**SSD 8636: ENGINEERING & TECHNOLOGY PRECINCT DEVELOPMENT
UNIVERSITY OF SYDNEY, DARLINGTON CAMPUS**

UNIVERSITY OF SYDNEY RESPONSE TO SUBMISSIONS

21 SEPTEMBER 2018

A1 DRAWING SHEET	Drawn: SPG
Co-ordinated: Michael Grave	Scale: 1 : 200 @ A1
Project Architect: Michael Bradburn	Date: 31/01/18
Project Director: David Holm	Revision: C
Drawing Number:	North:
A-DA-2102

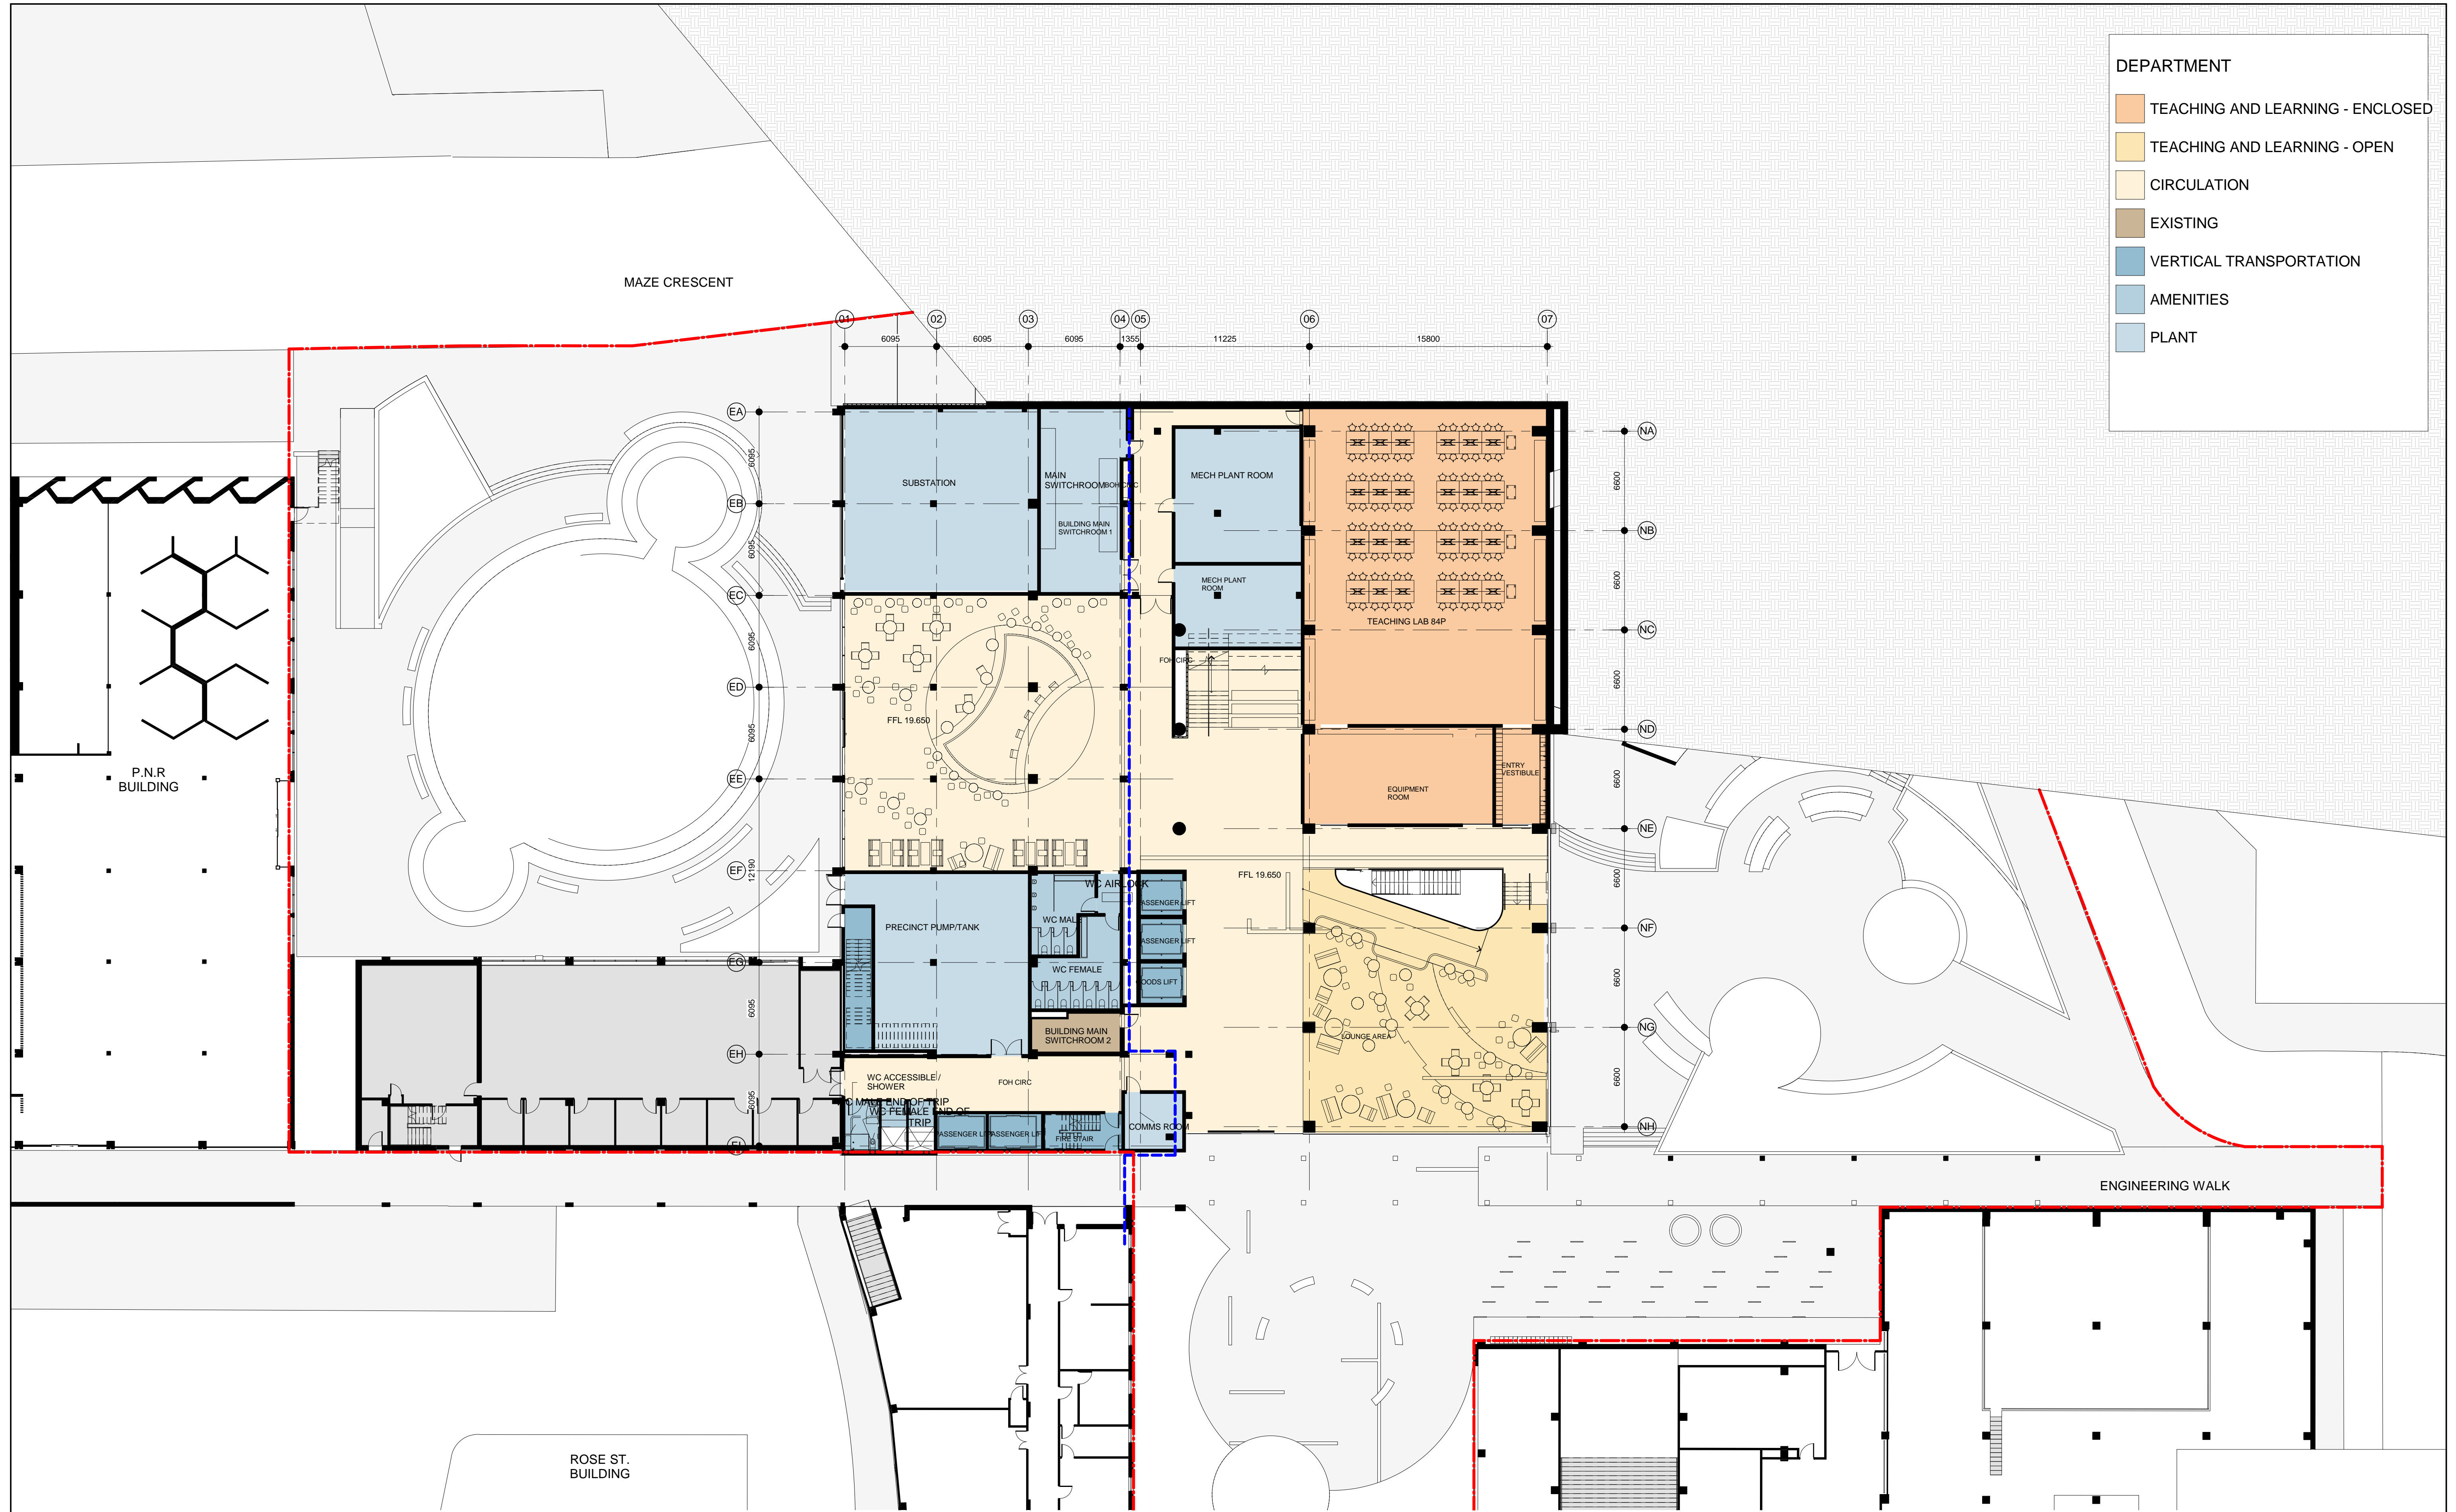
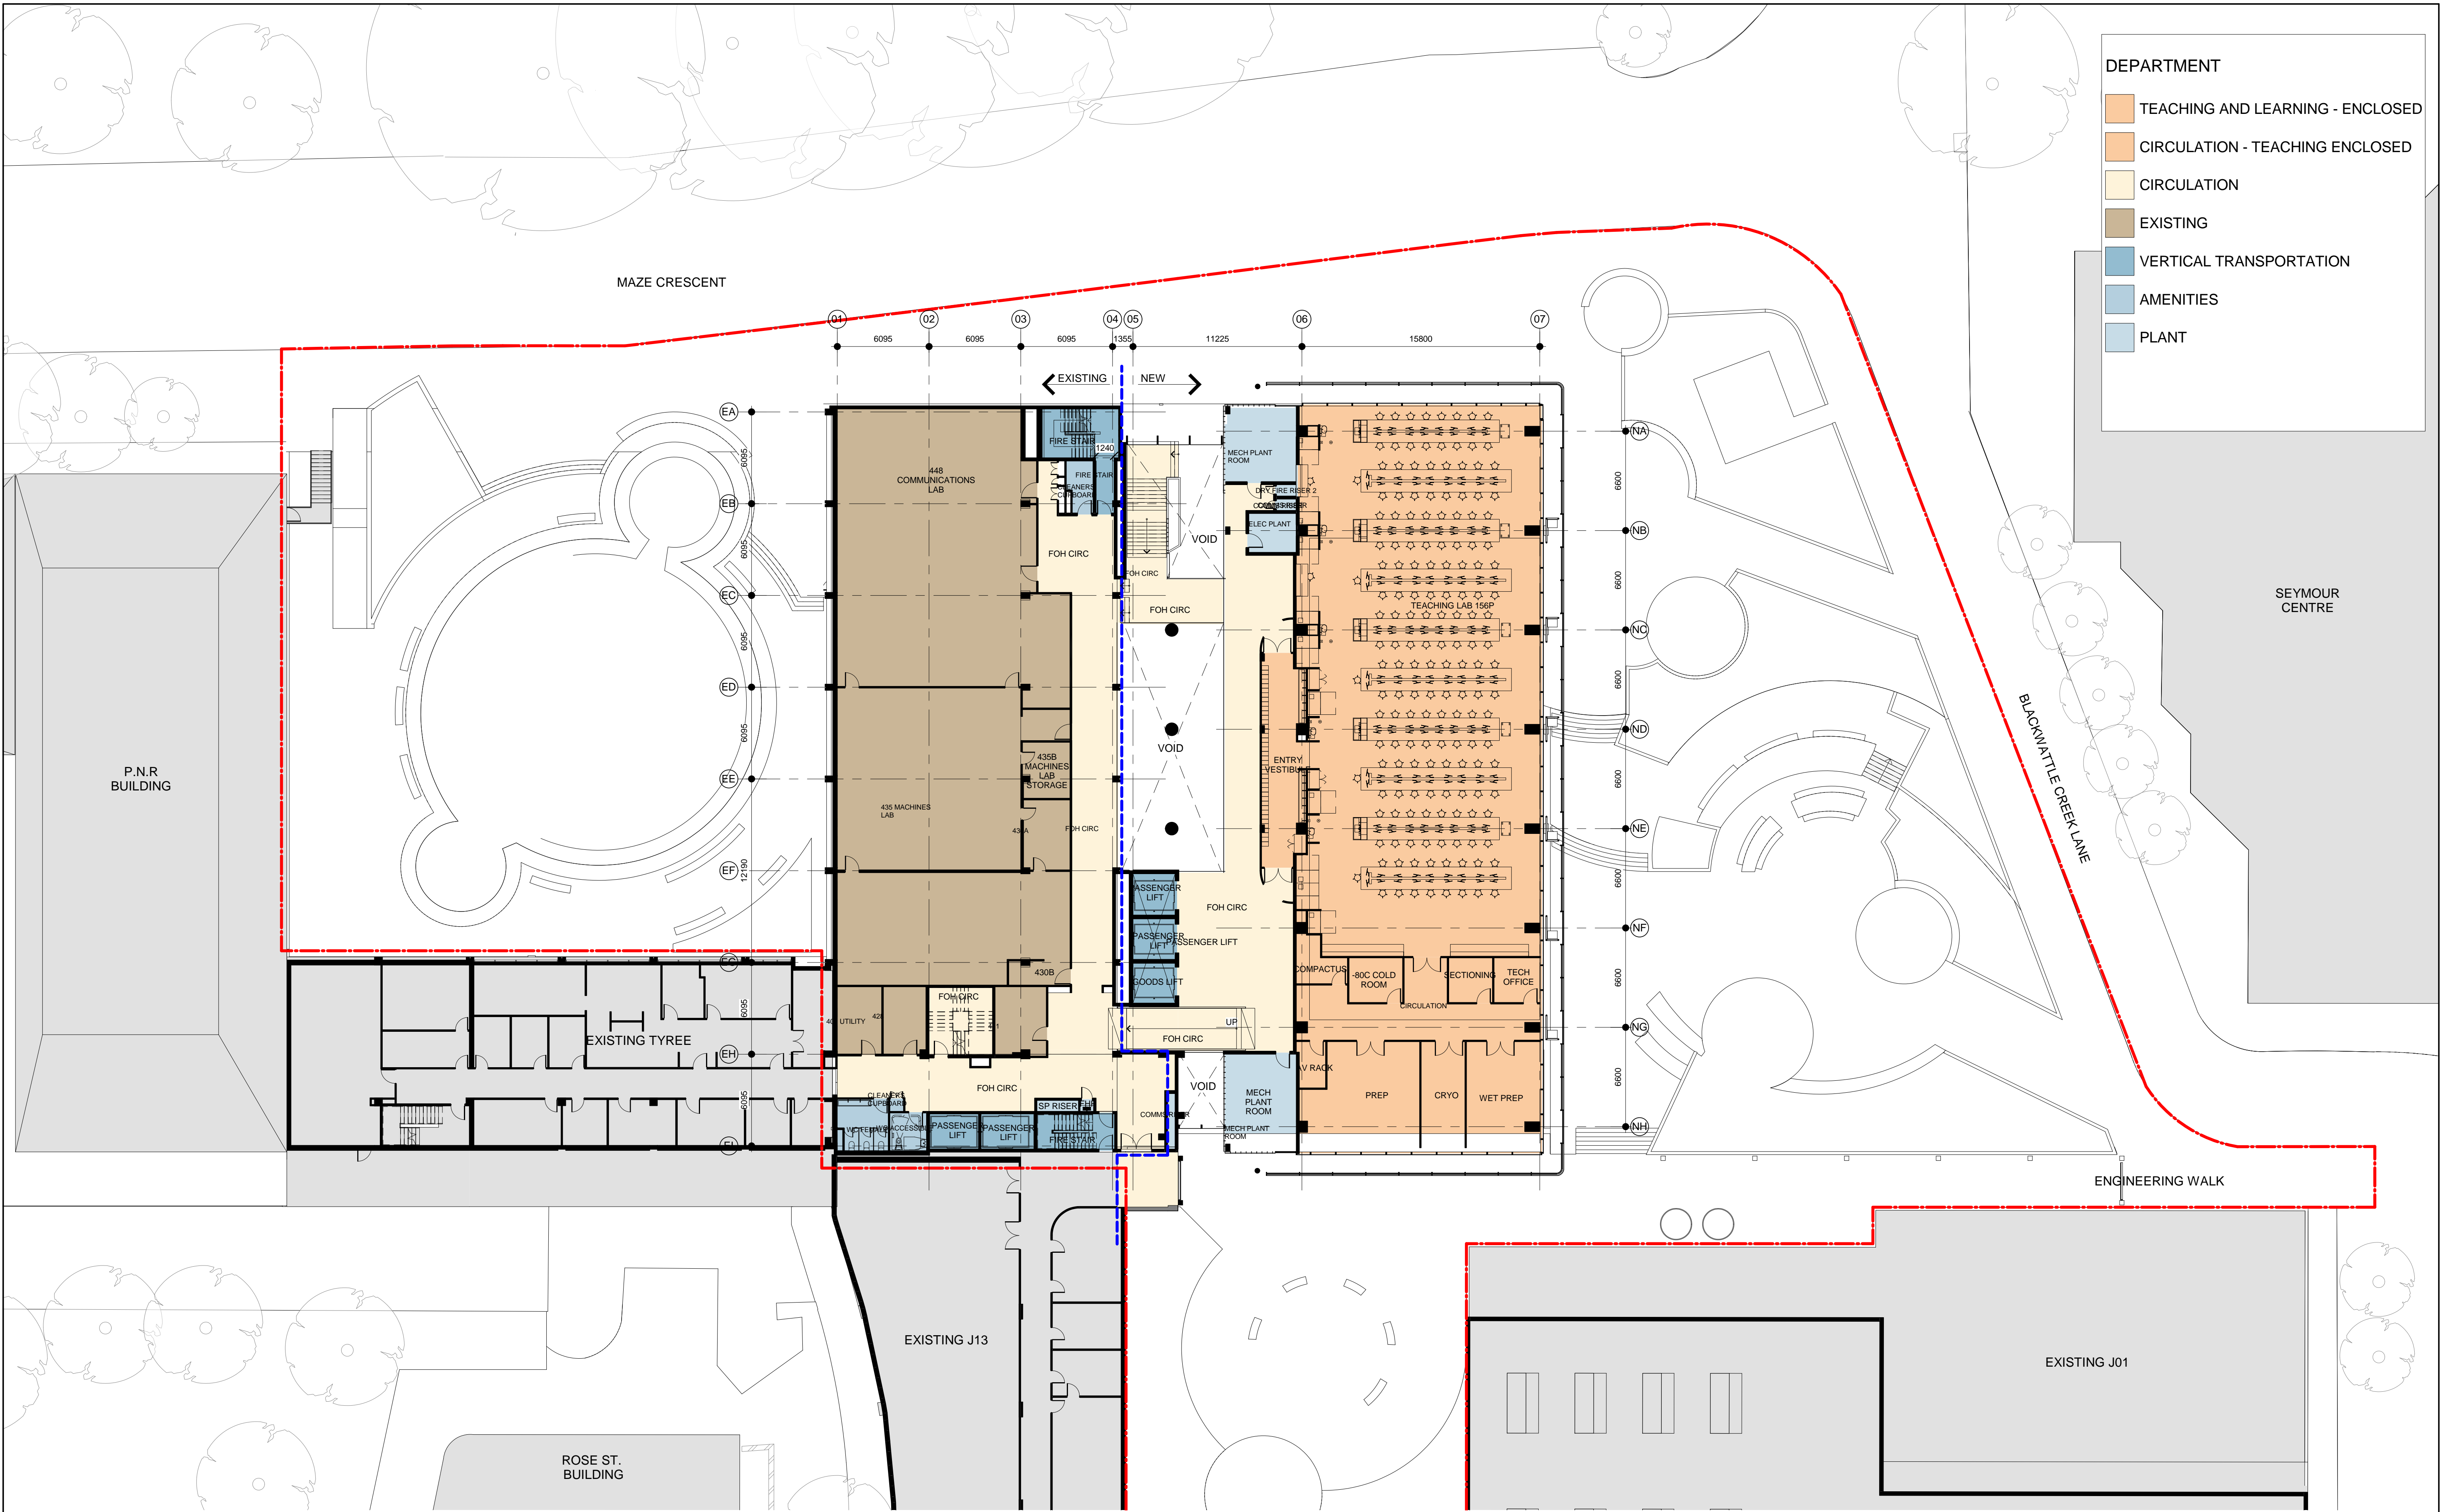
A-DA-2102	FLOOR PLAN - LEVEL 02	D	<ul style="list-style-type: none"> End of trip facilities (2 showers) added Updated bike rack count Deletion of engineering walk awning Addition of risers along grid 06 	<ul style="list-style-type: none"> 3.14 - End of trip facilities 1.06 - End of trip facilities
A-DA-2103	FLOOR PLAN - LEVEL 03	D	<ul style="list-style-type: none"> Updated stair at western end Deletion of the portals and engineering walk awning Landscaping updated Risers added along grid 06 	
A-DA-2104	FLOOR PLAN - LEVEL 04	D	<ul style="list-style-type: none"> "Interconnecting accommodation stair" annotation added "& School hub" added to the name of room name 448 Department filled region extent amended to suit floor plate Landscaping updated 	
A-DA-2105	FLOOR PLAN - LEVEL 05	D	<ul style="list-style-type: none"> Department filled region extent amended to suit floor plate Riser along grid 06 added Landscaping updated

<ul style="list-style-type: none"> • Coordination between existing and proposed pedestrian links have not been demonstrated by the application. 	<p>Pedestrian links coordination forms part of the University of Sydney Campus Improvement Program (2014 – 2020) Access Strategy, coordinated and delivered by the University of Sydney.</p> <p>The Strategy reinforces the pedestrian priority routes within the campus being along Maze Crescent and Blackwattle Creek Lane.</p> <p>It is considered that implementation of traffic management treatments proposed in appendix I and via the implementation of Traffic Management Arrangements will adequately mitigate safety concerns and will not lead to poor pedestrian amenity.</p> <p>Reference to Appendix D1, section 3B) Blackwattle Creek Lane and Shepherd Street traffic/pedestrian upgrades, page 3-4 and Appendix D2 for further clarification</p>
<ul style="list-style-type: none"> • End of Trip facilities including separate staff and student bicycle parking in an accessible on grade location are not clearly identified in the proposal. 	<p>End of trip facilities have been calculated and provided in accordance with the Sydney DCP 2012. Refer to Appendix A, page 7, drawing number A-DA-2102</p>
